From: Amanda Scholes on behalf of Planning.Responses
Sent: 03 November 2021 09:13
To: Planning Scanning
Subject: FW: Planning Consultation on: BR/242/21/OUT

Engineers Comments Regarding Flood Risk and Surface Water Drainage

Application No: BR/242/21/OUT

Description of Works: Outline application with all matters reserved except access for the demolition of existing bungalow to form new access for 6 No. detached chalet dwellings (resubmission following BR/124/21/OUT). This application may affect the setting of listed buildings & may affect the character & appearance of the Upper Bognor Road & Mead Lane Conservation Area.

ENVIRONMENT AGENCY RISK OF FLOODING FROM SURFACE WATER

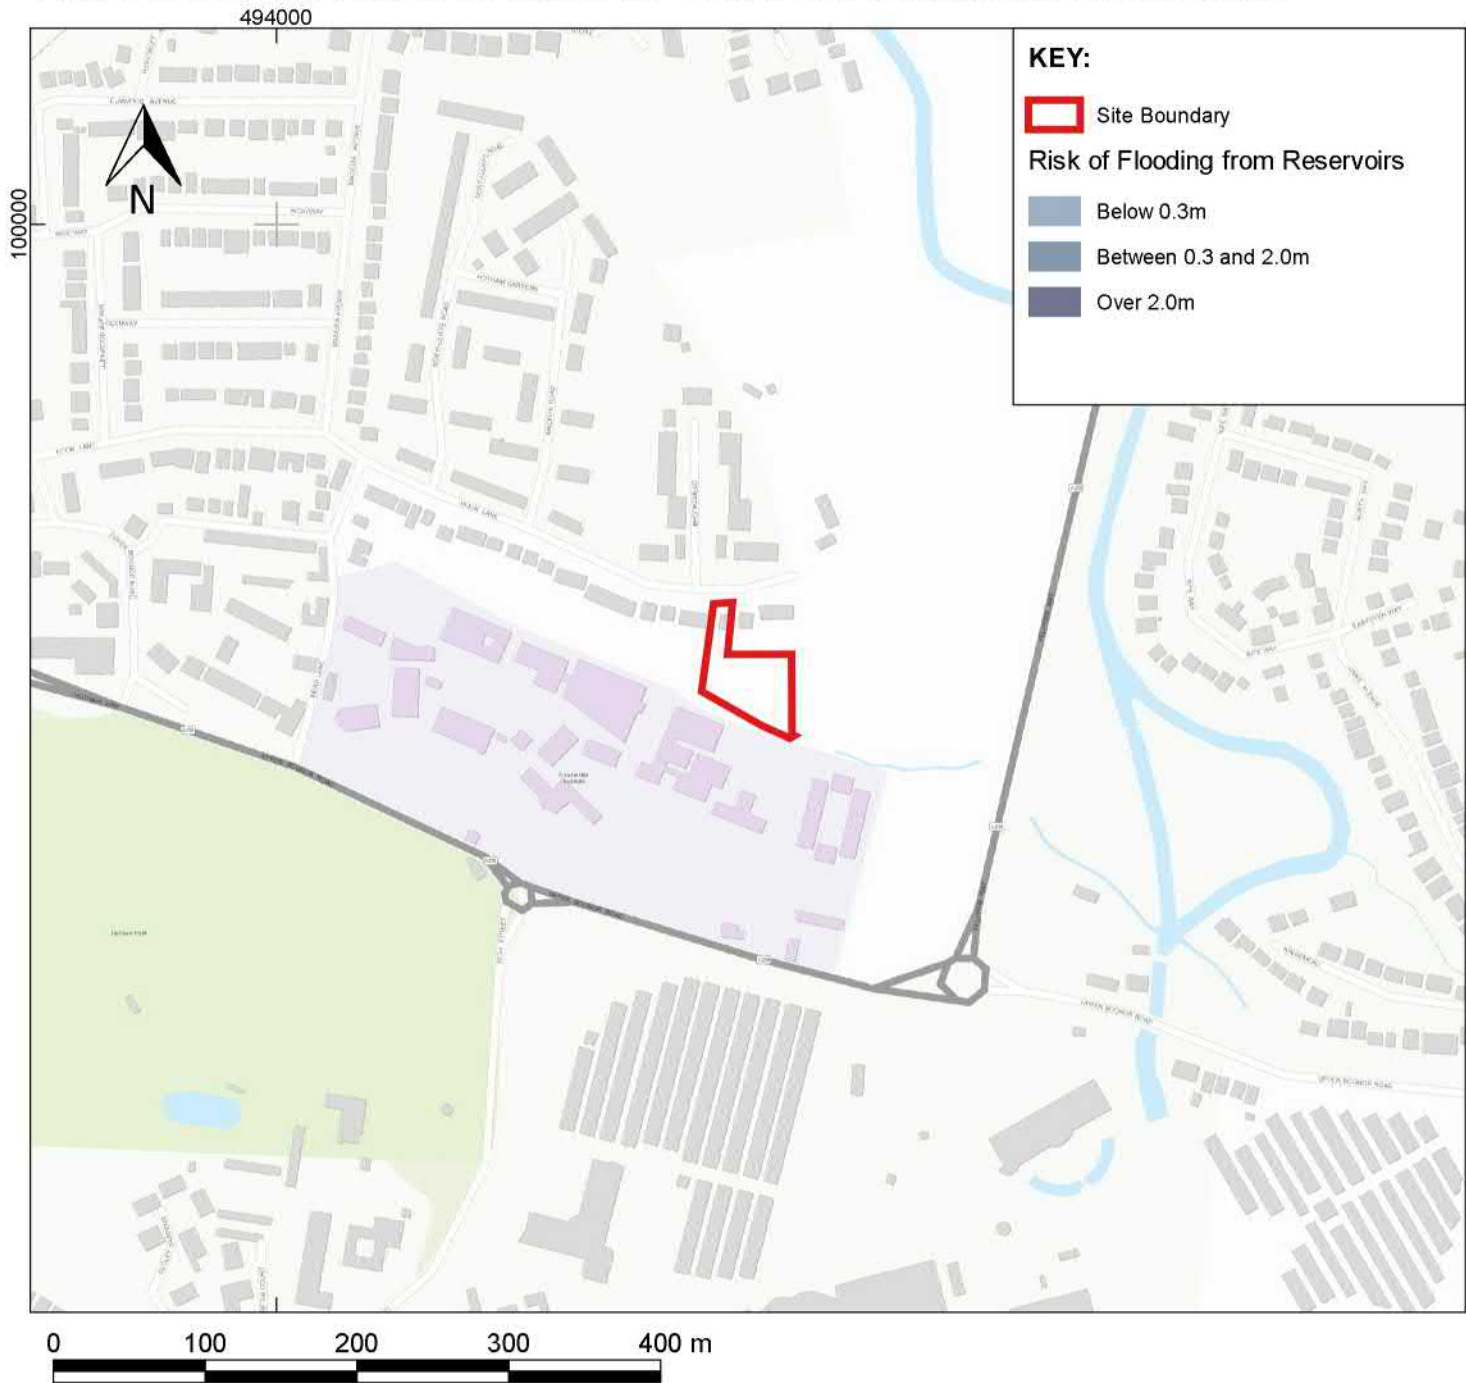
The details regarding how it will be ensured that proposals do not increase the risk of surface water flooding are vague. It must be demonstrated that proposals will not increase the risk of surface water flooding for events up to and including the 1 in100 year plus 40% climate change event. Where pluvial flood extents and depths are not available for this return period event the 1000 year event should be used. The FRA states that discrepancies between Environment Agency LiDAR and topographic survey mean that on site pluvial flood risk is less than that depicted by strategic mapping. If the applicant is disputing the strategic mapping then they should complete a site

specific pluvial model, using LiDAR and topographic data, as per industry standard methodology. The emphasis is on the applicant to disprove strategic scale flood mapping.

Greater detail on predicted pluvial flood levels is required, along with proposed displaced volumes and compensation. As per NPPF 2021 updates, it must be evidenced that the development will be safe from all sources of flood risk and will not increase flood risk (considering all sources) elsewhere. Therefore the development must not displace flood water for events up to and including the 1 in 100 year +40% climate change event (compensatory volume is required in addition to the drainage requirements of the new development). Displaced volume should be clearly mapped, along with compensatory volume to show where these volumes will be stored so that the impact can be easily assessed by both ourselves and the Planning Officer. It is impossible to know if storage can be provided below ground as infiltration testing and groundwater monitoring have not been completed.

SURFACE WATER DRAINAGE
STRATEGY

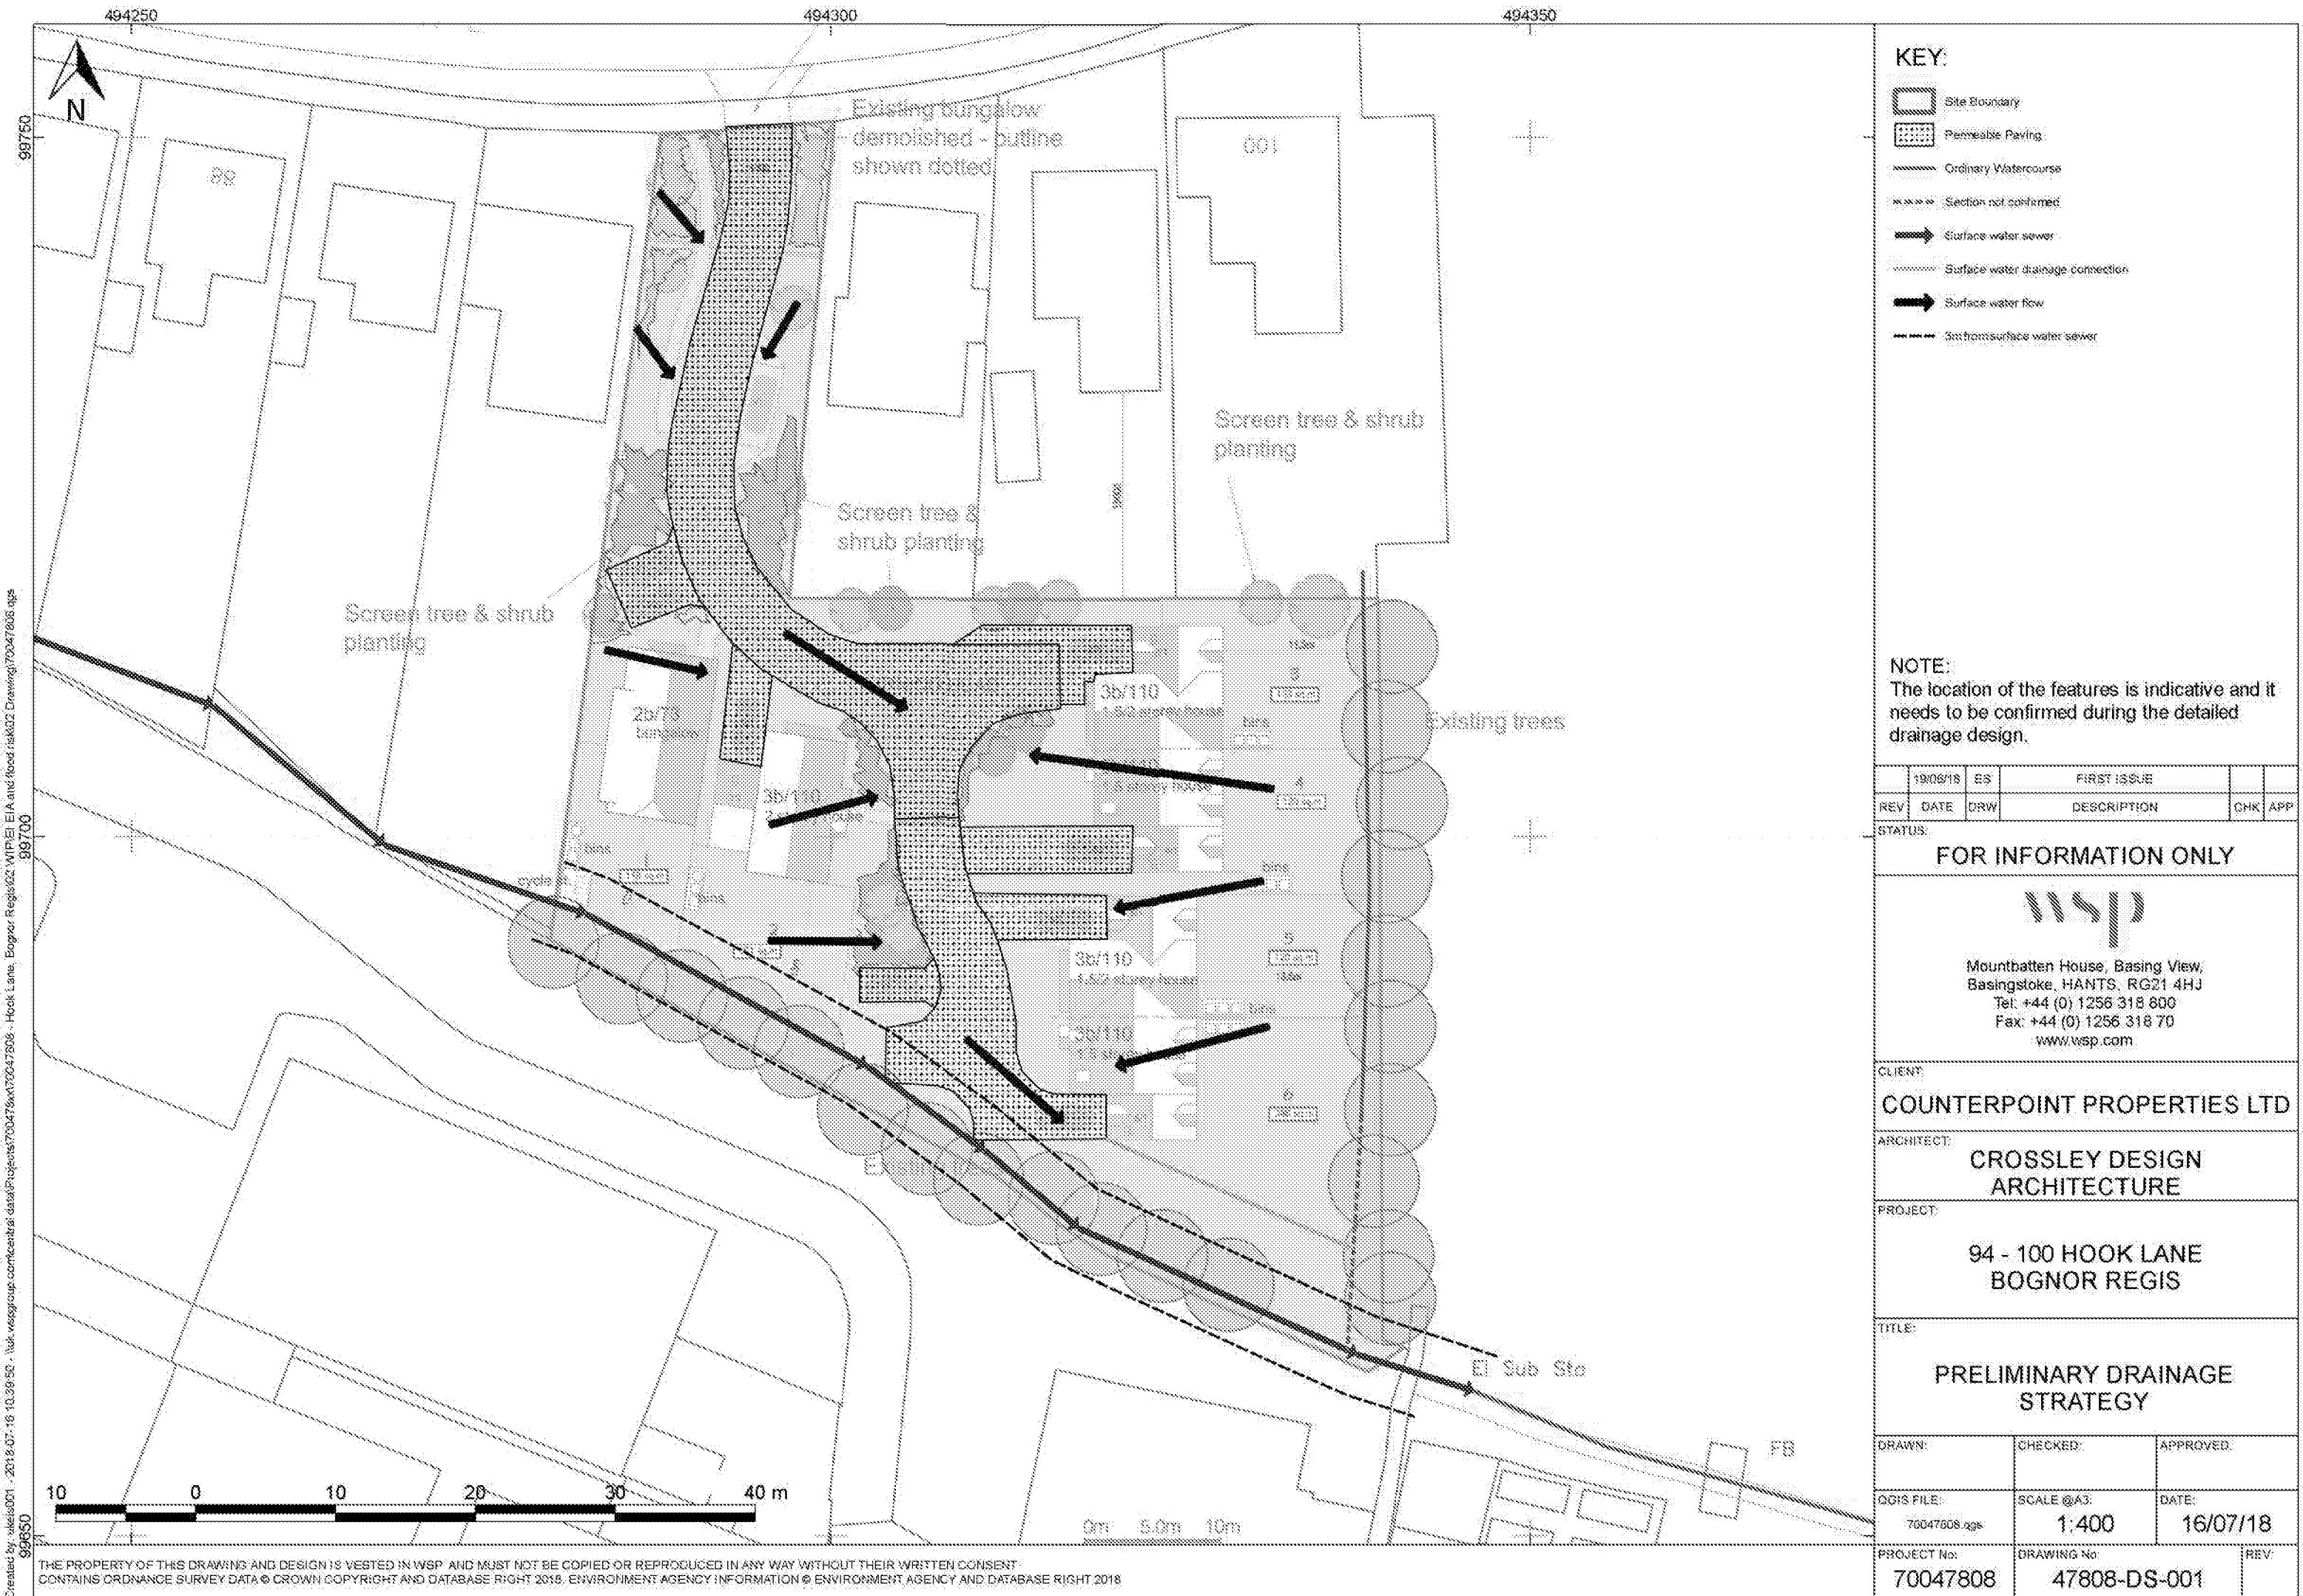
The surface water drainage strategy proposes attenuation within road sub-base, and a discharge rate of 5l/s. Infiltration testing and winter groundwater monitoring must be undertaken on site to demonstrate that the hierarchy is being followed. If attenuated discharge is required it should be limited to greenfield QBar for all events, or 2l/s if greenfield QBar is less than this. Surface water must not be stored in areas at risk of flooding, i.e. it should be stored outside of predicted fluvial and pluvial flood extents. It is unclear how a policy compliant surface water drainage solution can be delivered here.

1. Winter groundwater monitoring results.
2. A site specific assessment of pluvial flood risk.
3. Details of displaced pluvial volume, and compensatory pluvial volume.
4. A revised surface water drainage strategy with discharge limited to a maximum of 2l/s.
5. Details of the watercourse, and evidence that a minimum of a 3m clear buffer is provided within development proposals.
